Our Ref: OUT10/221
Your Ref: 07_0010

22 December 2010

Re: MP07_0010 - Environmental Assessment for Residential, Commercial and Tourist Development and Environmental Works at Ocean Drive, Lake Cathie

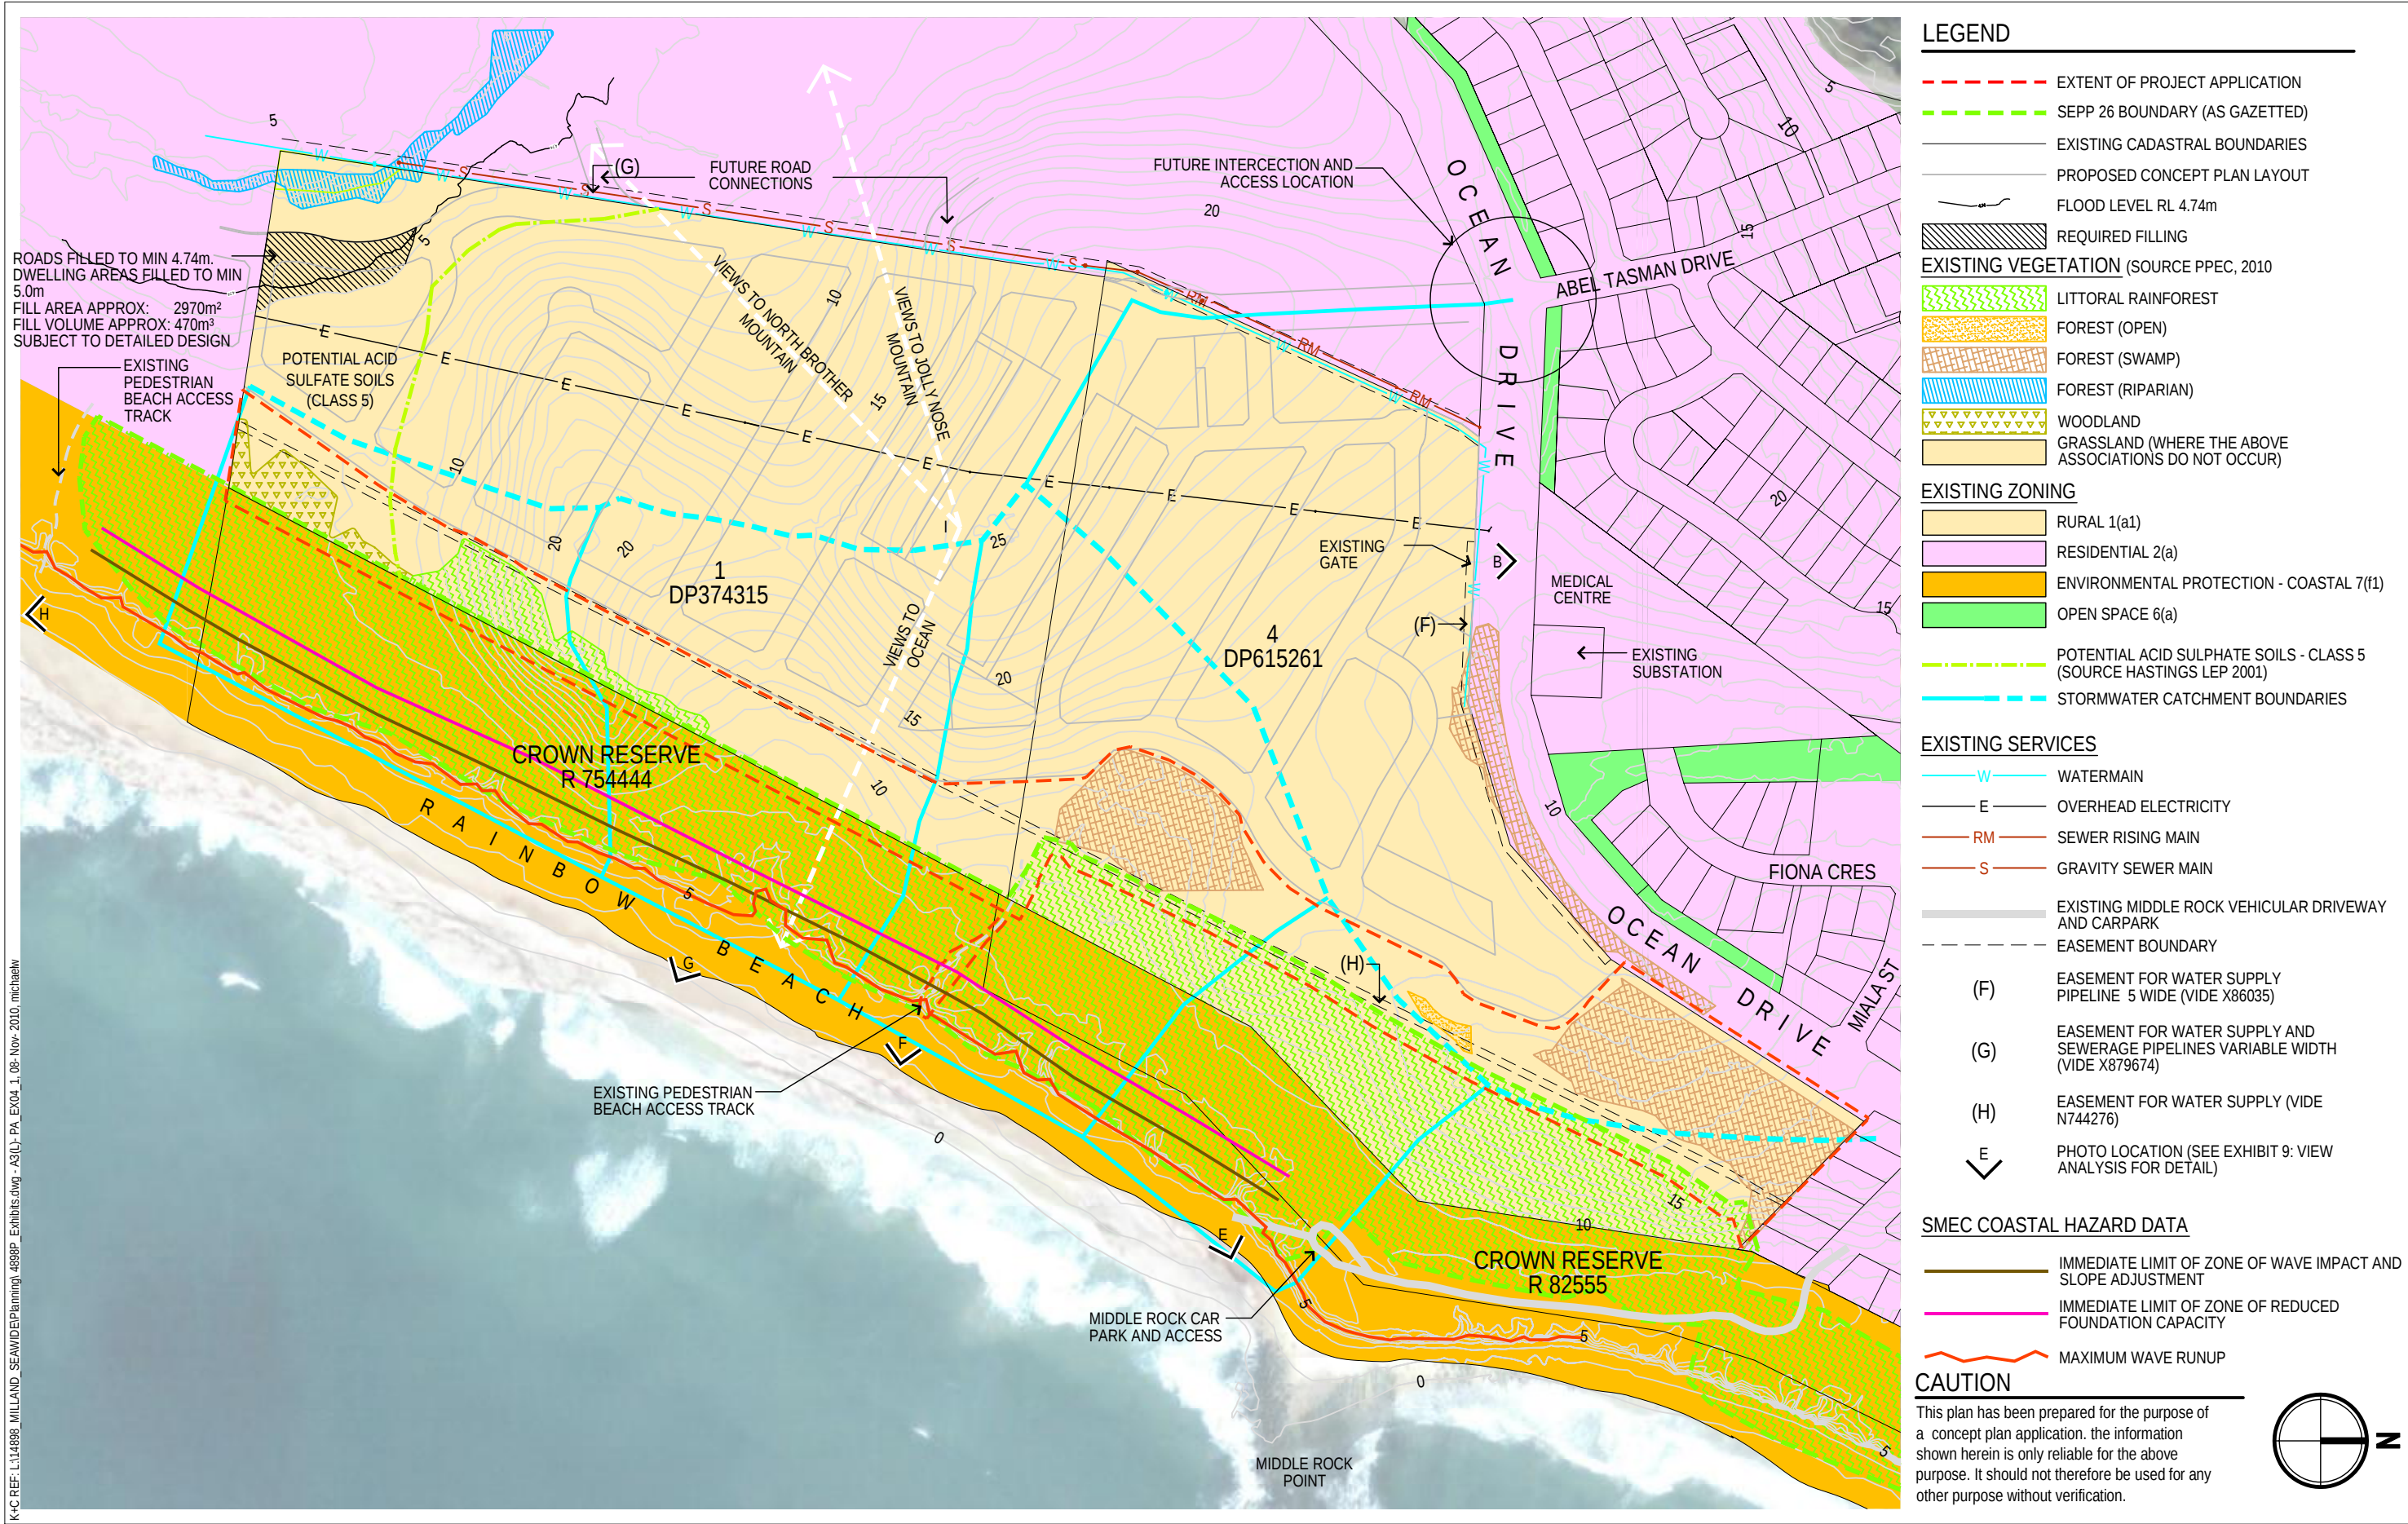
The EA notes that a 40-60 metre vegetated buffer has been included in the concept plan, but does not specify the width of the total buffer. Exhibit PA 04 (Sheet 01) shows that the concept plan provides some sections of littoral rainforest with this buffer, while others are provided with no buffer. The buffer width has not been applied uniformly along the length of existing vegetation.

The EA acknowledges that the effects of climate change including sea level rise and increased storm surge are likely to result in beach erosion and recession. This will see the existing littoral rainforest effectively sandwiched between the beach and the planned development over time. This makes inclusion of an appropriate buffer even more important to provide the littoral rainforest with some opportunity to migrate landward.
